**WELWYN HATFIELD BOROUGH COUNCIL
EXECUTIVE DIRECTOR - PLANNING, PUBLIC PROTECTION AND GOVERNANCE**

DELEGATED APPLICATION

Application No: 6/2018/2022/FULL
Location: 6 Salvisberg Court Otto Road Welwyn Garden City AL7 3EQ
Proposal: Replacement of full-height windows with french doors and installation of window
Officer: Mrs June Pagdin

Recommendation: Granted

Drawing for
PP-07107899

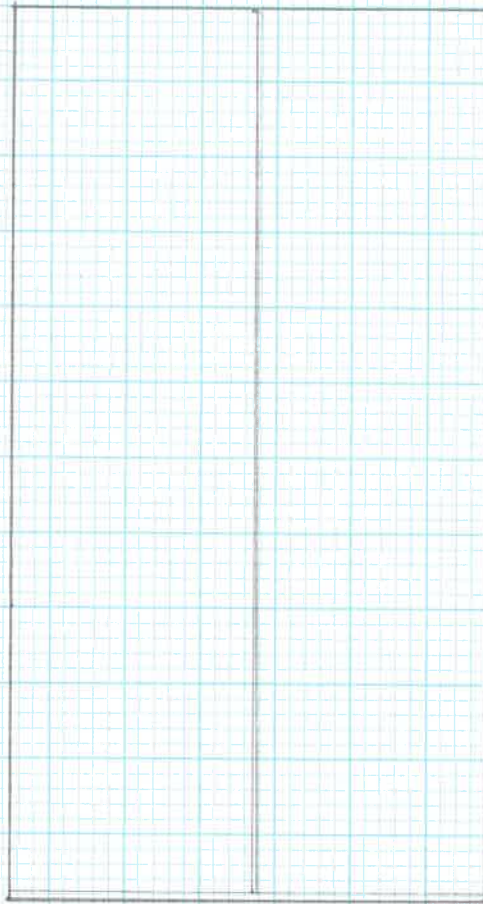
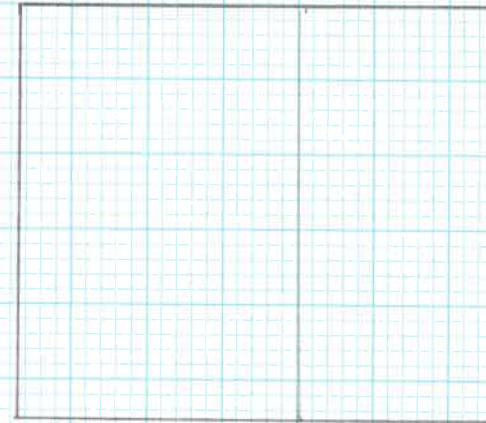
The existing full height window opening would be used for the patio doors. A new window opening will be installed to the side of the doors, positioned to match the pattern of existing spacing between doors and windows on this elevation.

The proposed frames would match the colour and style of the existing windows and the patio doors in those flats that have them. The new windows will also be in the same colour and style as neighbouring windows in this elevation.

The opening patio doors will each be 0.6m wide and when open will not impose unduly on the communal amenity space and not impinge upon the planter positioned 1.7m from the north elevation.
